DECISION DELEGATED TO HEAD OF PLANNING

Application No: H08-0312-26 **Applicant:** Wilf Hammond Homes Ltd

Proposal: Erection of 4 No Self-Build Dwellings & Garages

Location: Land West Of Spalding Road Gosberton Spalding

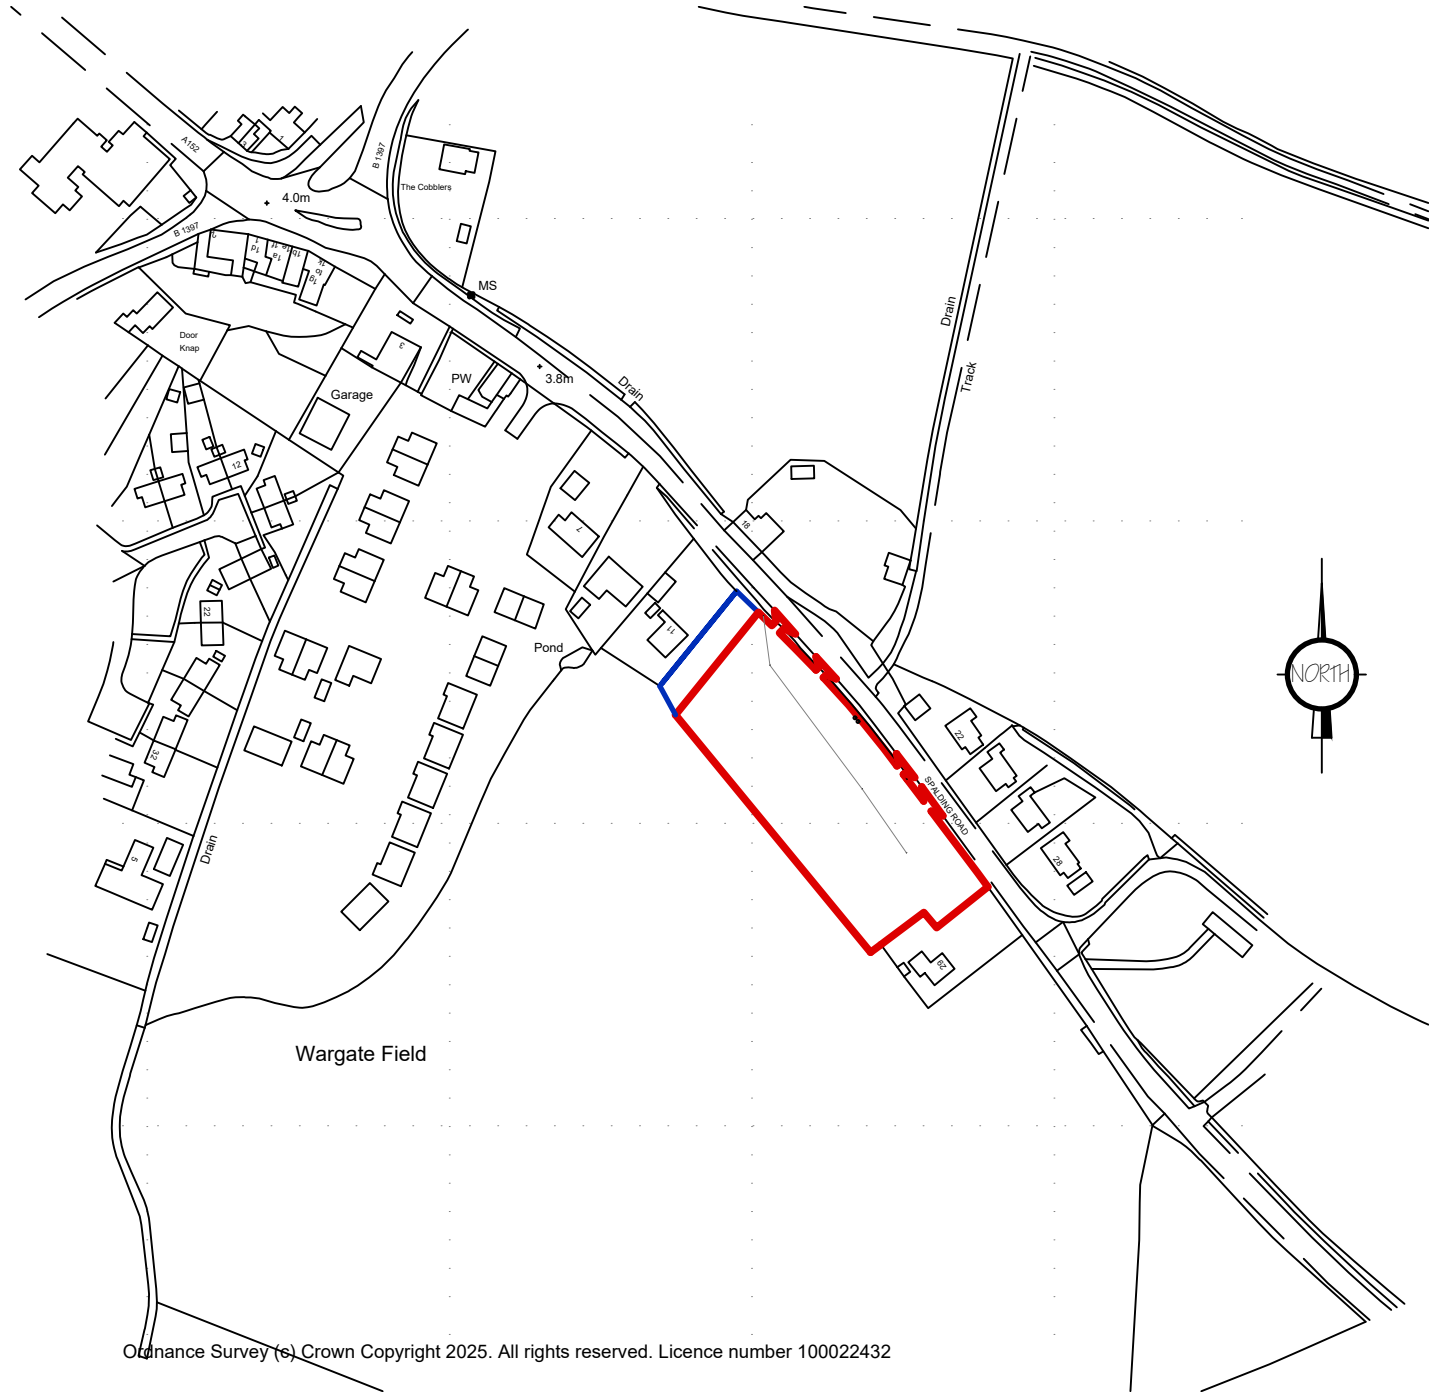
-4330-24 01E Site Plan - Proposed & Location Plan - Amendment 2Comments

-We request that a total of 4 integrated universal nest bricks (e.g., S Brick, Swift Nesting Brick, Manthorpe, Swift Bricks: The 'Universal' Nest Brick - by Dick Newell | CIEEM) are incorporated into the external fabric of one or both buildings. These should be located at a height of 4+ m metres, on the north or east elevations to avoid overheating, and grouped colonially where possible, in accordance with best-practice guidance such as British Standard BS 42021:2022. The bricks must be installed during the construction phase and retained thereafter for the lifetime of the development.

-We also request that one integrated bat box (e.g., Integrated / Built-In Bat Boxes, Integrated Eco Bat Box | The Nestbox Company) are added to each dwelling.

-In both cases, the authority requires the applicant to submit sufficiently detailed maps that indicate

the proposed location of bird/bat boxes on-site. These are required to enhance biodiversity and to be in line with Local Plan Policy 7.2.14.

-Having reviewed the updated proposed site plans, we are now confident that, as the site is less than 0.5 ha and is a self/custom build development, the proposal on the amended site plan is exempt from BNG.

F	L.C.HIGHWAYS AMENDMENTS	APR 2026
E	SITE AREA AMENDED	APR 2026
D	CLIENT AMENDMENTS	APR 2026
C	RED LINE UPDATED - PLANNING	MAR 2026
B	CLIENT AMENDMENTS	MAR 2026
A	CLIENT AMENDMENTS	MAR 2026
ref	revision	date

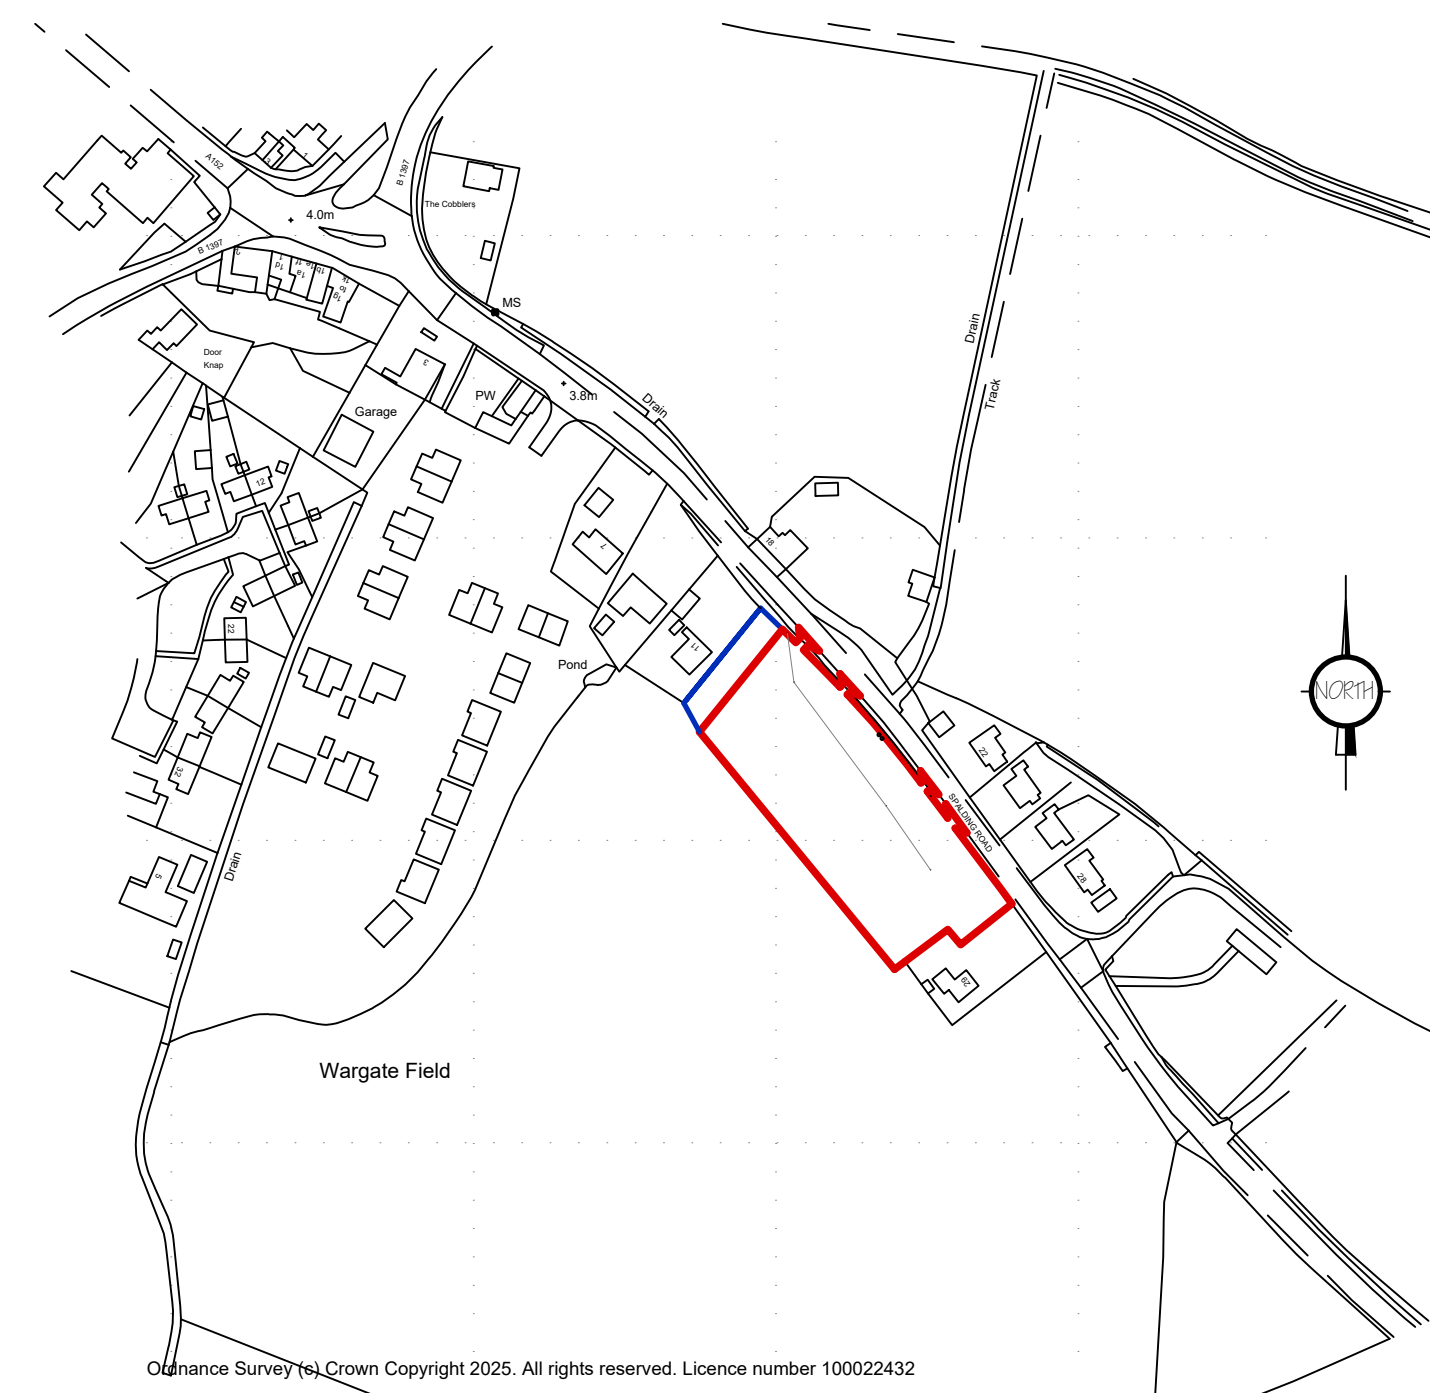
ADDITIONAL INFORMATION REQUIRED Visibility is to be demonstrated for each access point, and it shall be in accordance with Manual for Streets - 40 limit. The field access will also need to be upgraded to Lincolnshire County Council Specification - this should be detailed on the proposed site plan. There are a number of telegraph poles within the site and fronting the site that need to be

detailed on the proposed site plan.

Comments: Erection of 4 No self-build dwellings & garages - Outline with access to be considered. Visibility has been demonstrated for each access point, and it is in accordance with Manual For Streets. There is an existing footway on Spalding Road that connects to the site. When an application is submitted for Reserved Matters please be aware that gravel drives should be set back from the highway so as not to drag loose material onto the highway. The field access and all new access points will be constructed to Lincolnshire County Council Specification. The proposal will not have an adverse impact on the public highway. As Lead Local Flood Authority, Lincolnshire County Council is required to provide a statutory planning consultation response with regard to drainage and surface water flood risk on all Major applications. This application is classified as a Minor Application and it is therefore the duty of the Local Planning Authority to consider the surface water flood risk and drainage proposals for this planning application.
